LOT 5, FALCON MARKETPLACE

GRADING & EROSION CONTROL DOCUMENTS

EPC STORMWATER REVIEW COMMENTS ARE SHOWN IN ORANGE BOXES WITH BLACK TEXT

COVER SHEET

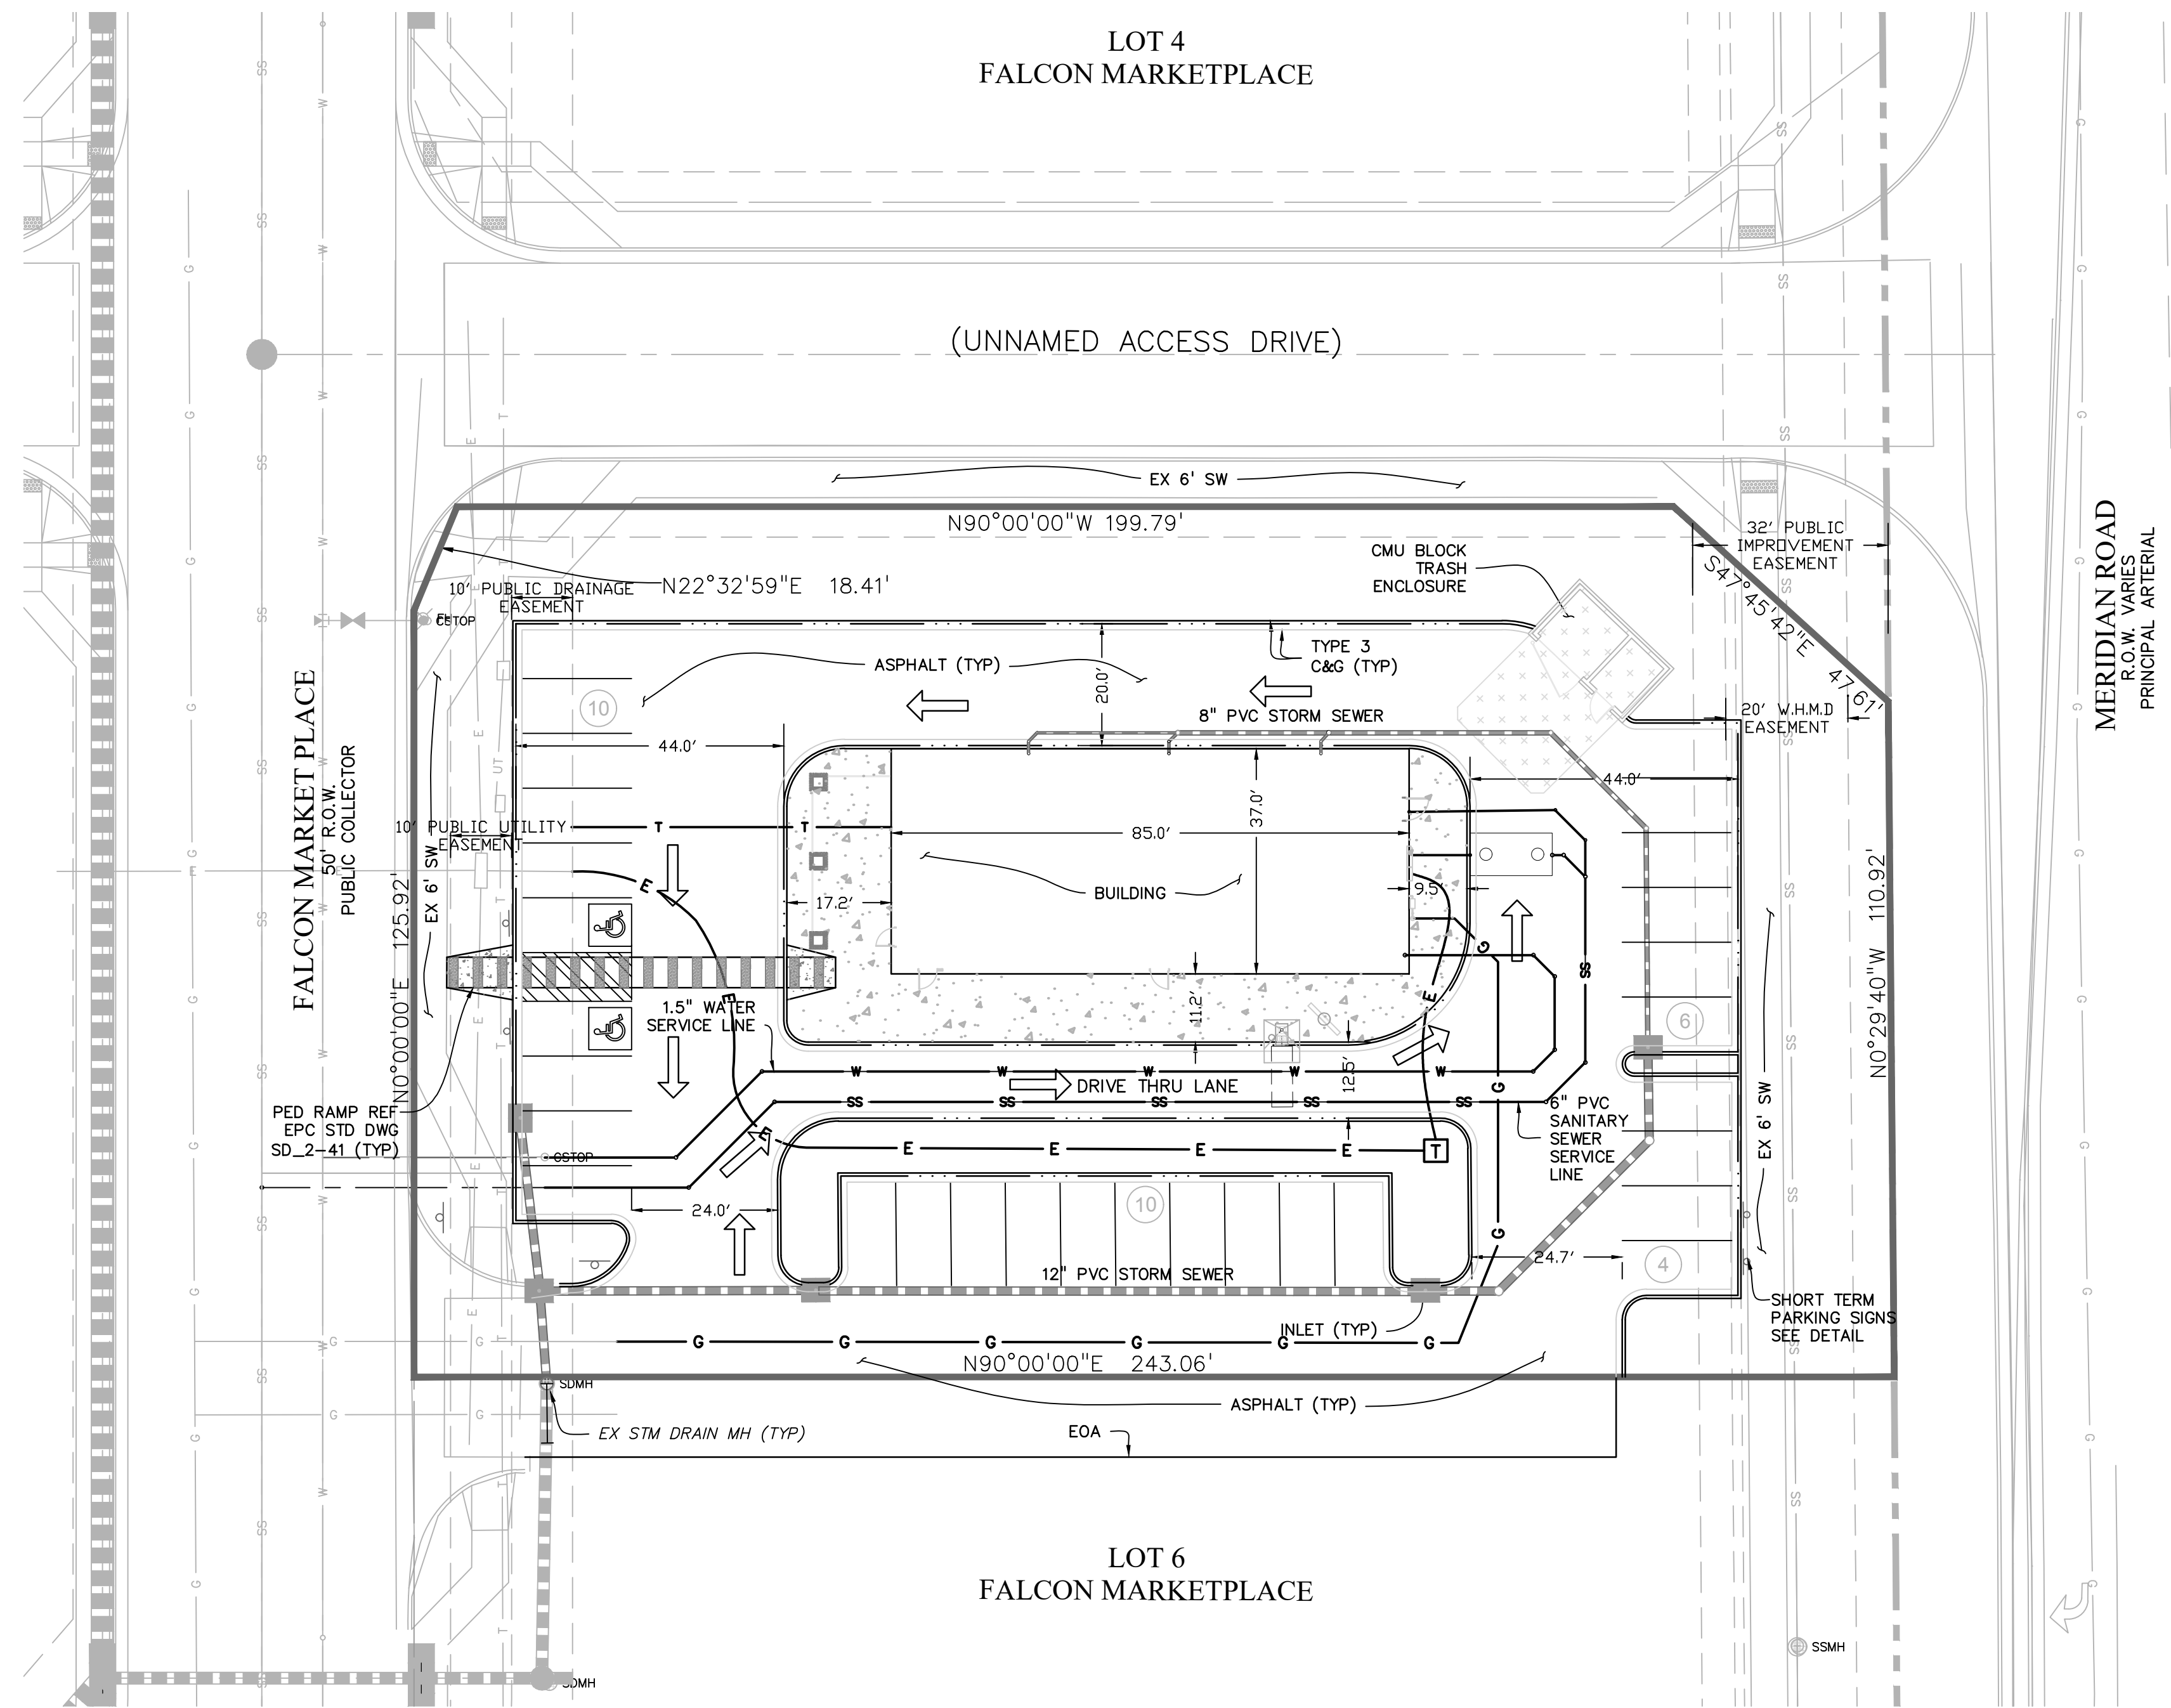
Correct to EPC Std Signature Block shown below

Add PCD File # PPR-22-002

Use inset to show location of existing pond.

Label adjacent city/town/jurisdictional boundaries, subdivision names, and property parcel numbers

INITIAL GRADING & EROSION CONTROL PLAN

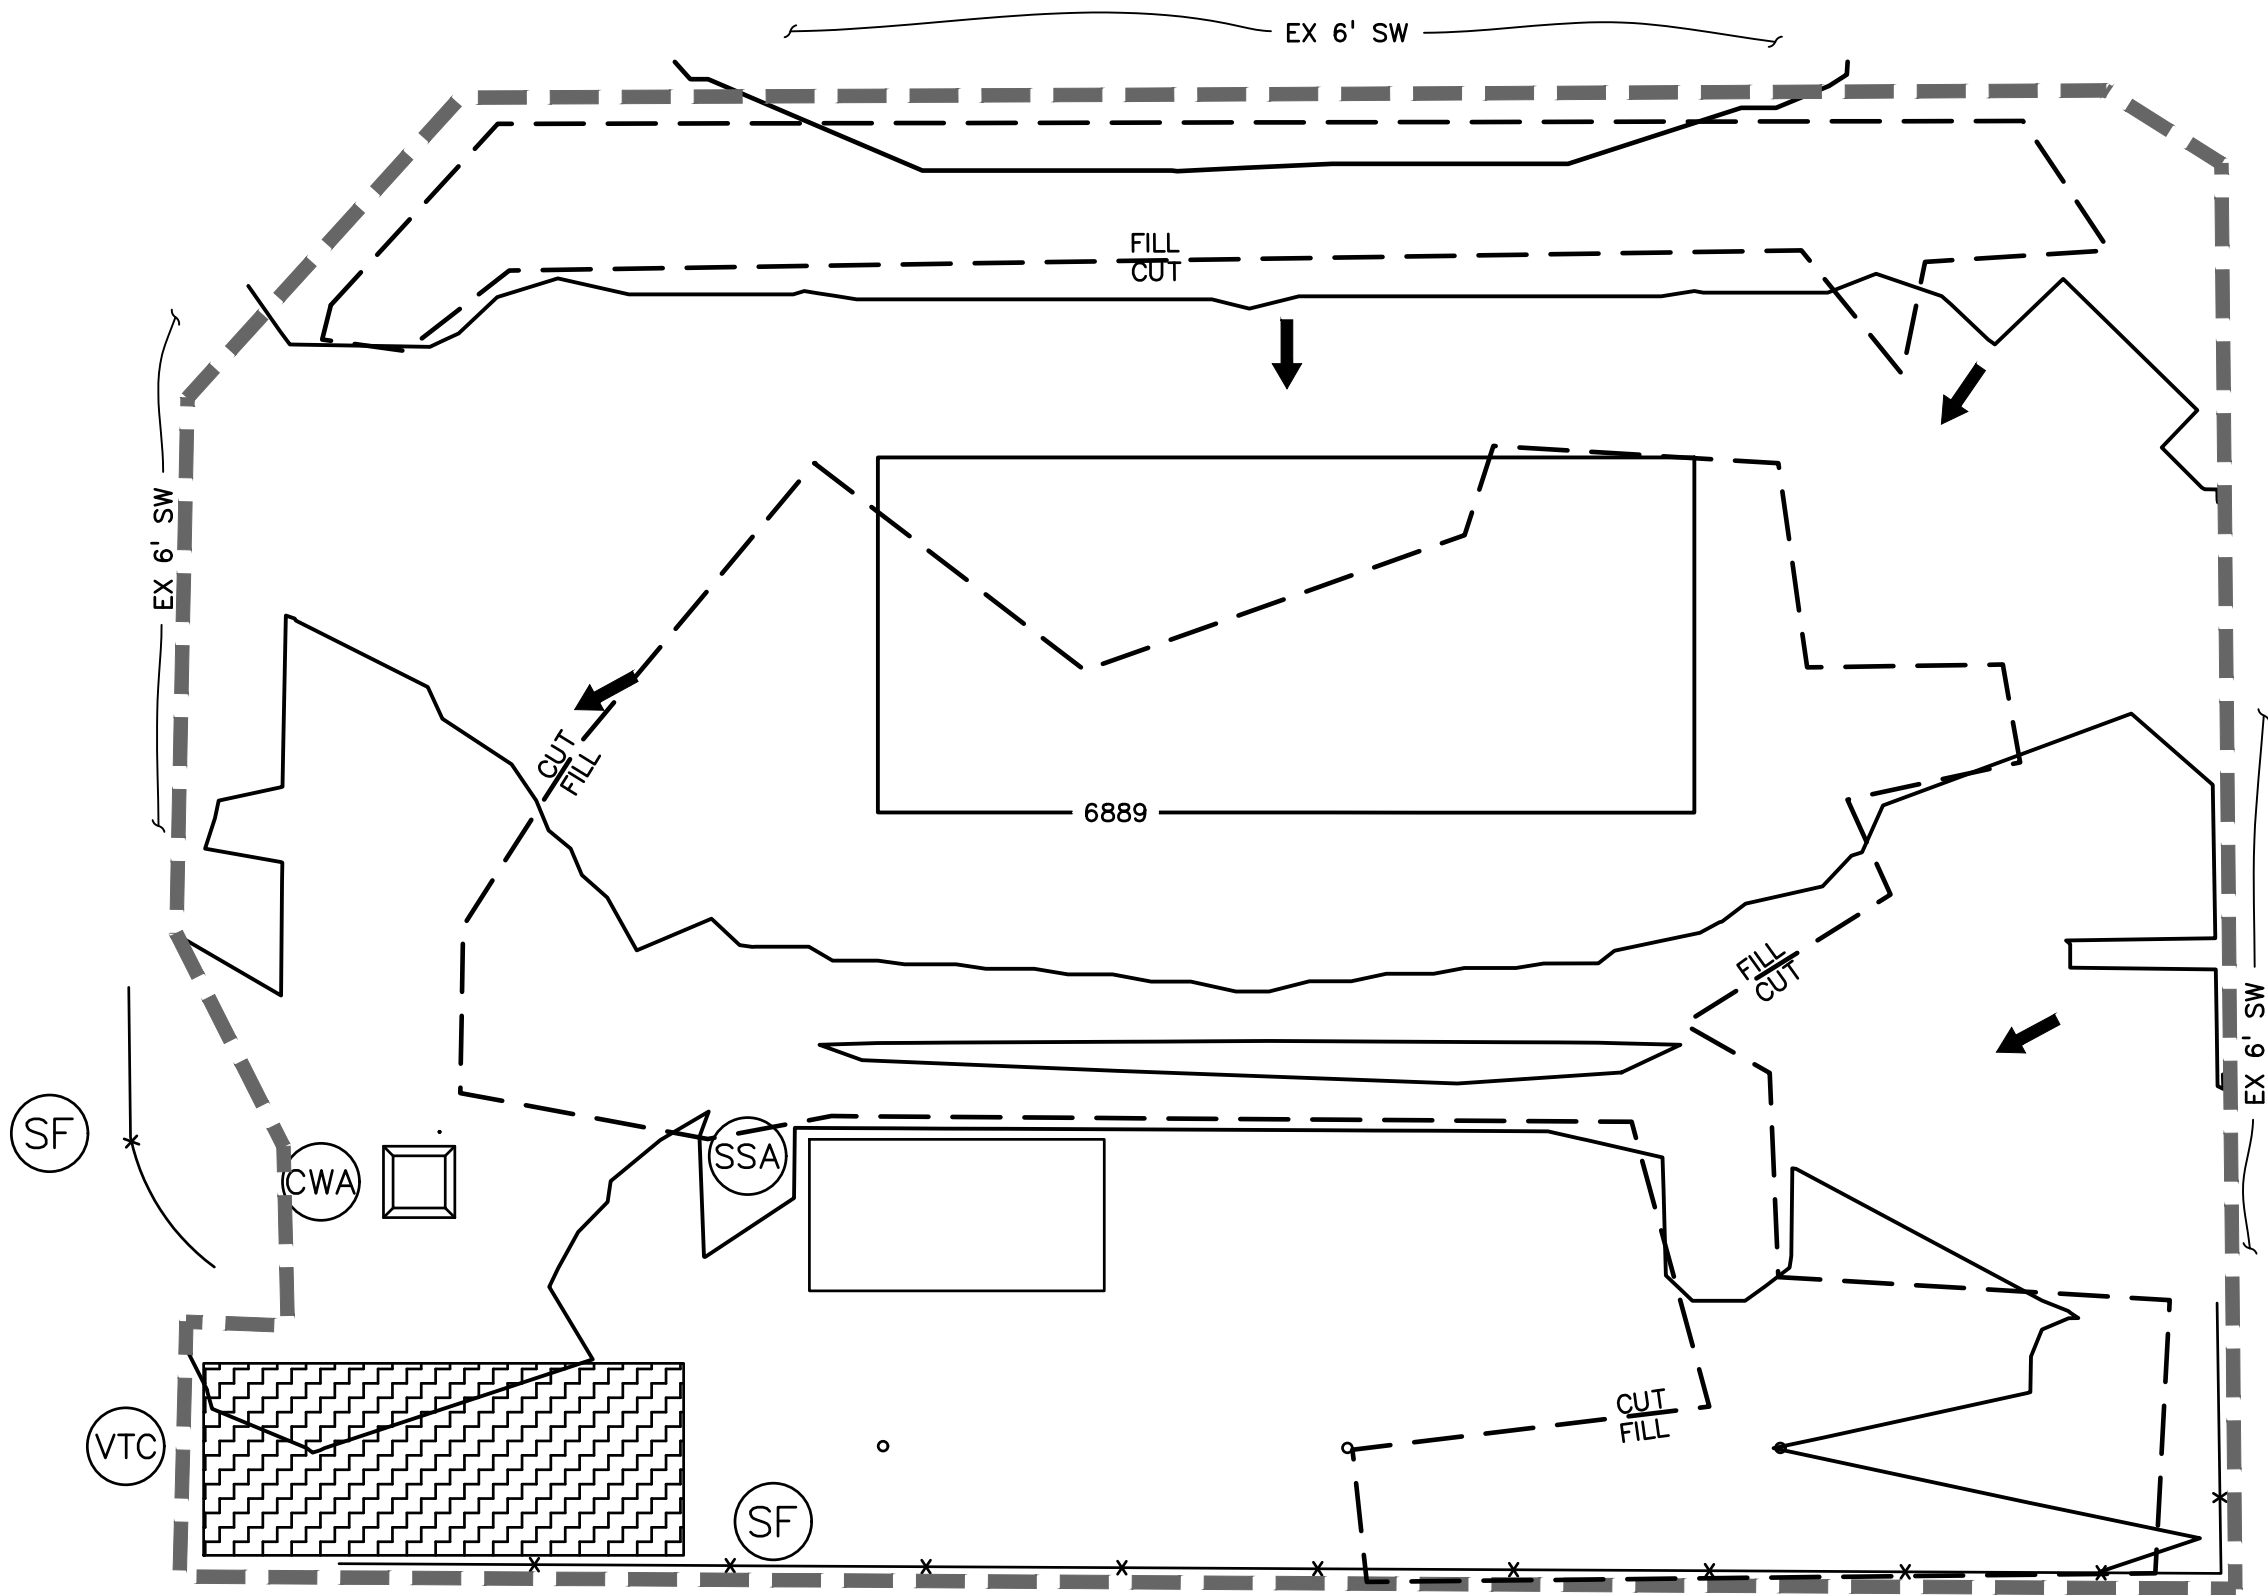
add silt fence

VTC should be a minimum of 50' in length

add a note about existing vegetation at the site.

in order to comply with the swmp requirements please add the following notes:
 - No batch plants will be utilized onsite.
 - The site is not within 50' of any surface waters

is there another access location so that you can avoid covering MH with VTC?

show the ped ramp linework

Staff recommends providing type/grade specification for PVC pipe used for stormwater

Staff recommends identify grade breaks and providing additional slope arrows.
Staff is assuming there is a high point grade break along the driveway centerline.

show all easements
